Planning Application Ref: **FP/274/18/PL**

Location: **10 Felpham Gardens, Felpham, PO22 8QS**

Description of works: **Demolition of 1 No. house & erection of 2 No. detached chalet style dwellings with garaging & car parking**

PROPOSED PLOT PLAN

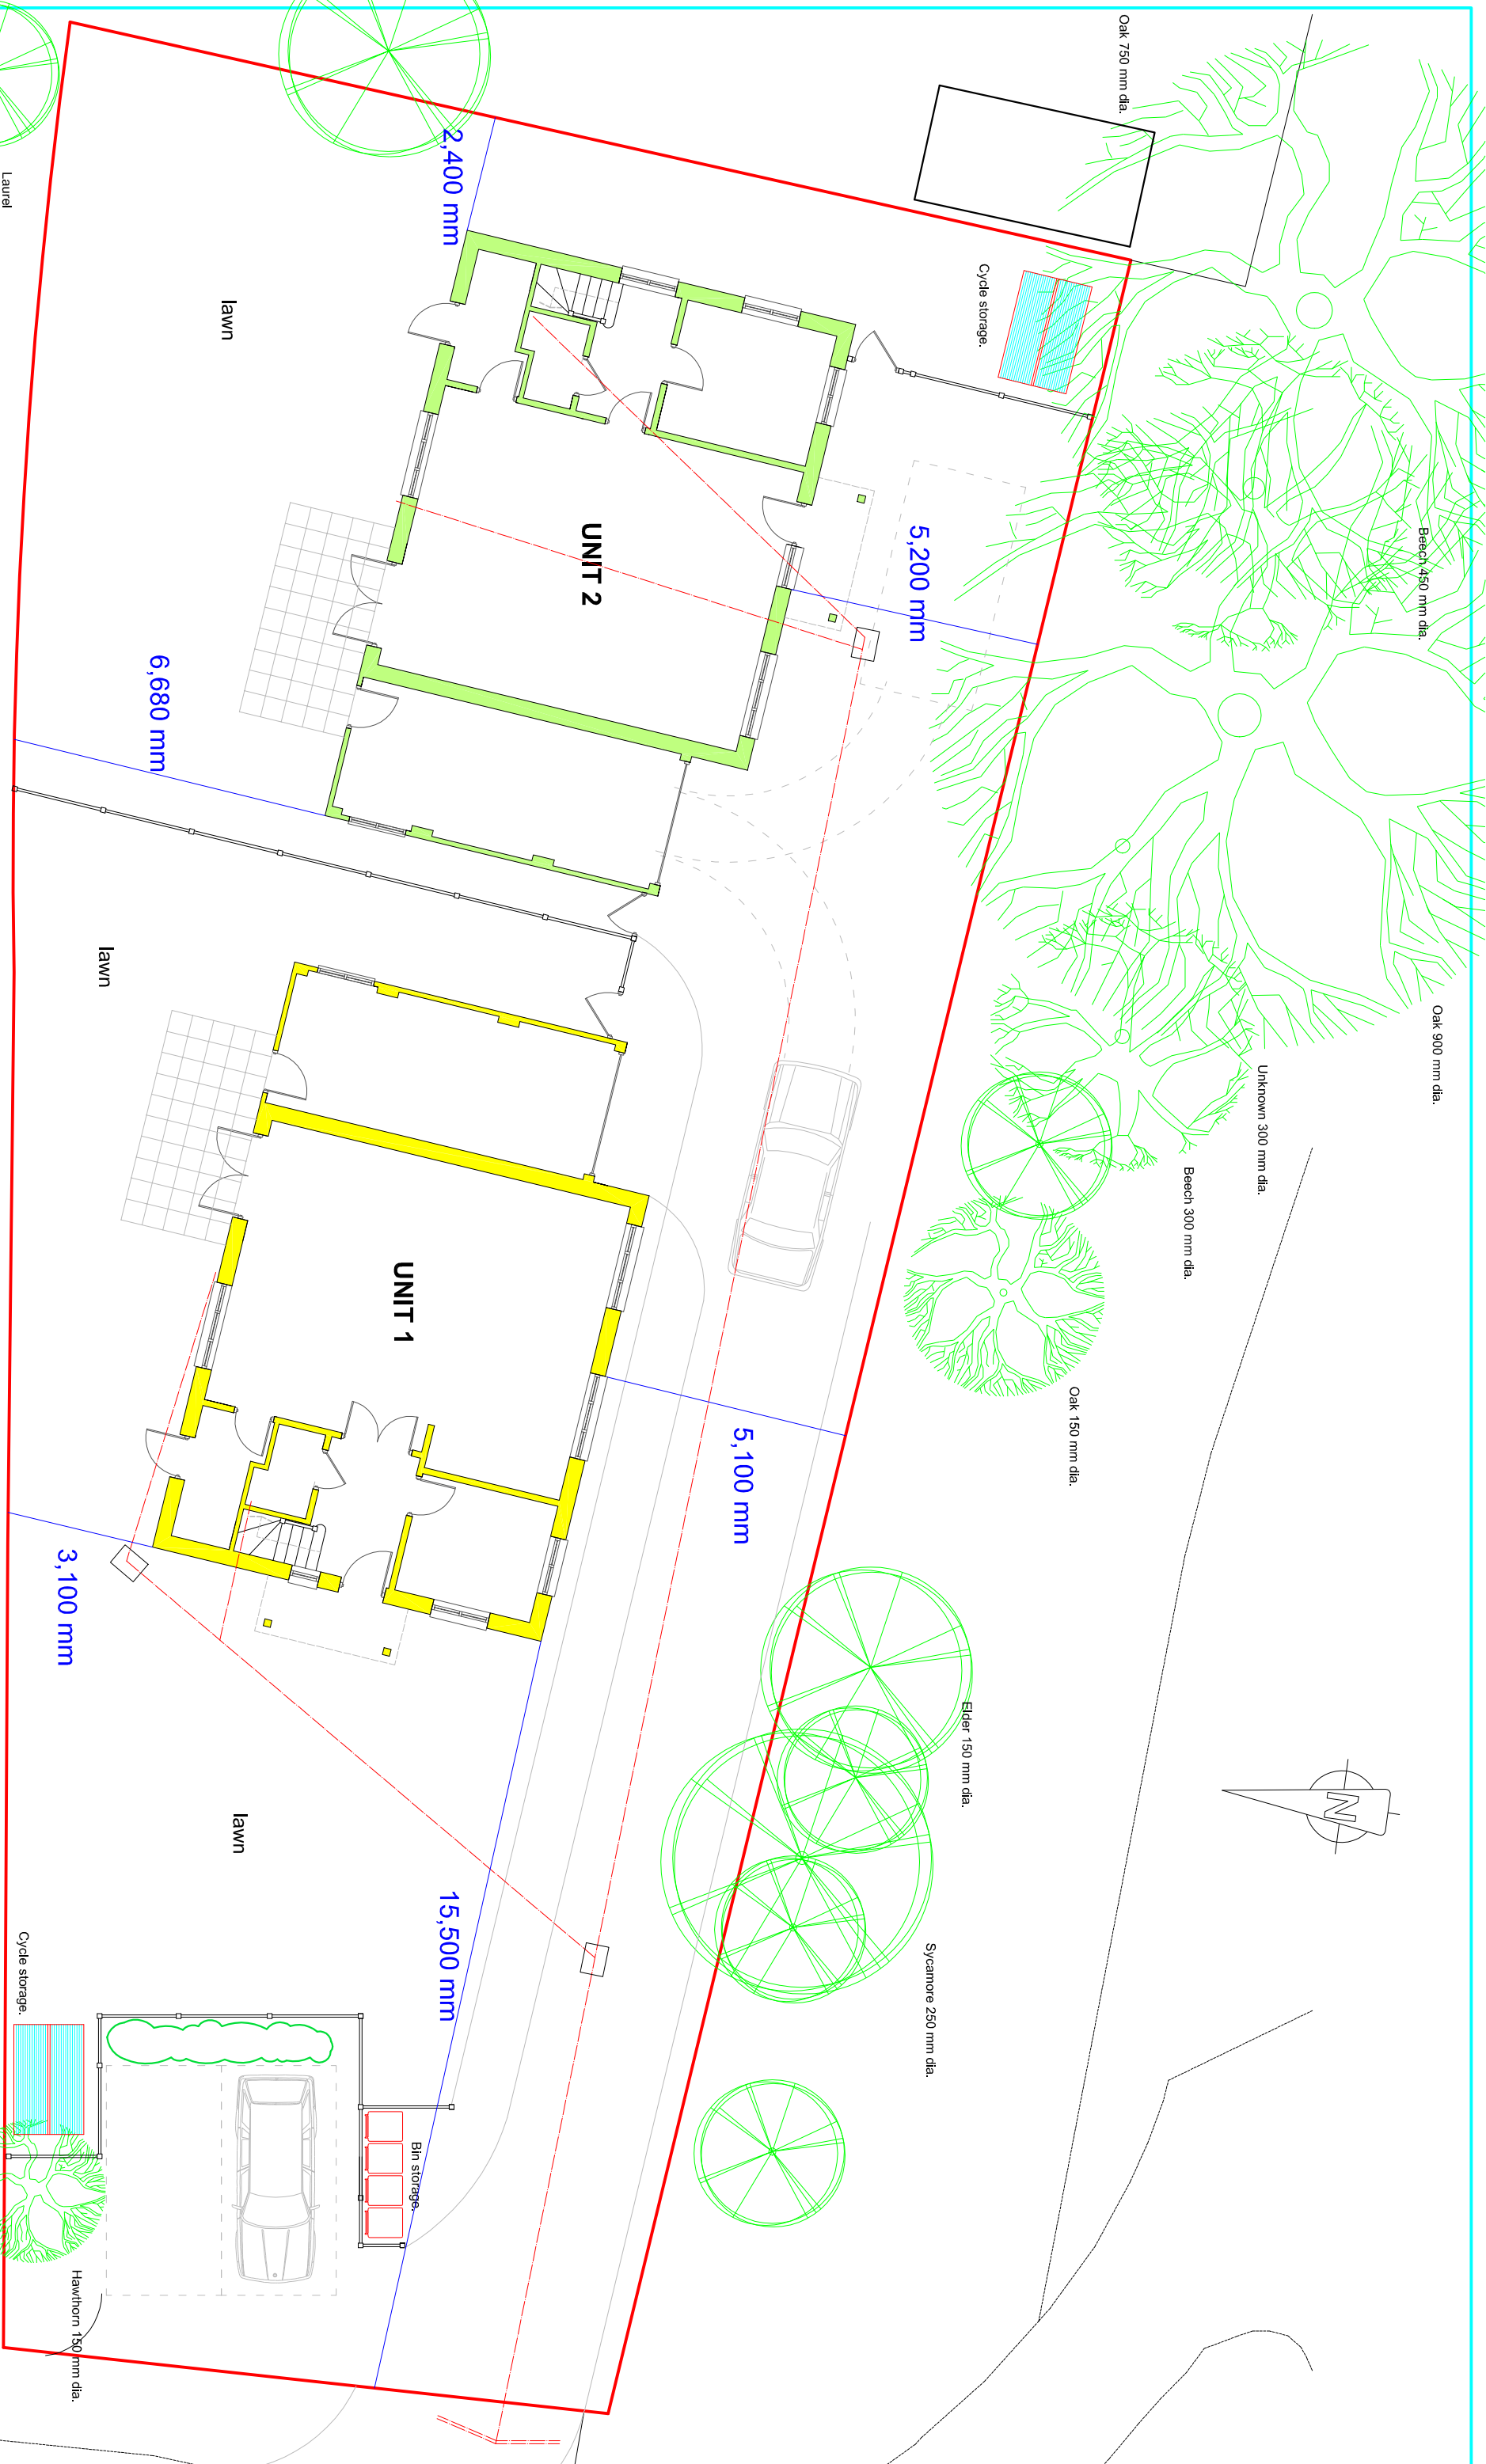
- There are a number of important trees within the adjacent public park that will be impacted upon from above and below ground. The tree protection measures proposed are adequate in principle and the extent of pruning work to accommodate the development is reasonable; both being achievable without undue detriment to the visual amenity they currently provide if correctly executed.

- Before the site is occupied or any machinery is introduced to the site or demolition work or construction work or alterations to existing ground levels takes place a **PRE-COMMENCEMENT Site Meeting** is to take place between the Arun DC Tree Officer and the Arboricultural Expert representing the site owners – at this meeting all protective fencing will be inspected to verify it is 'Fit for Purpose' as required under British Standard 5837:2012 and have been erected and positioned exactly as shown on the **Tree Protection Plan, Appendix A, Dec 2018.**
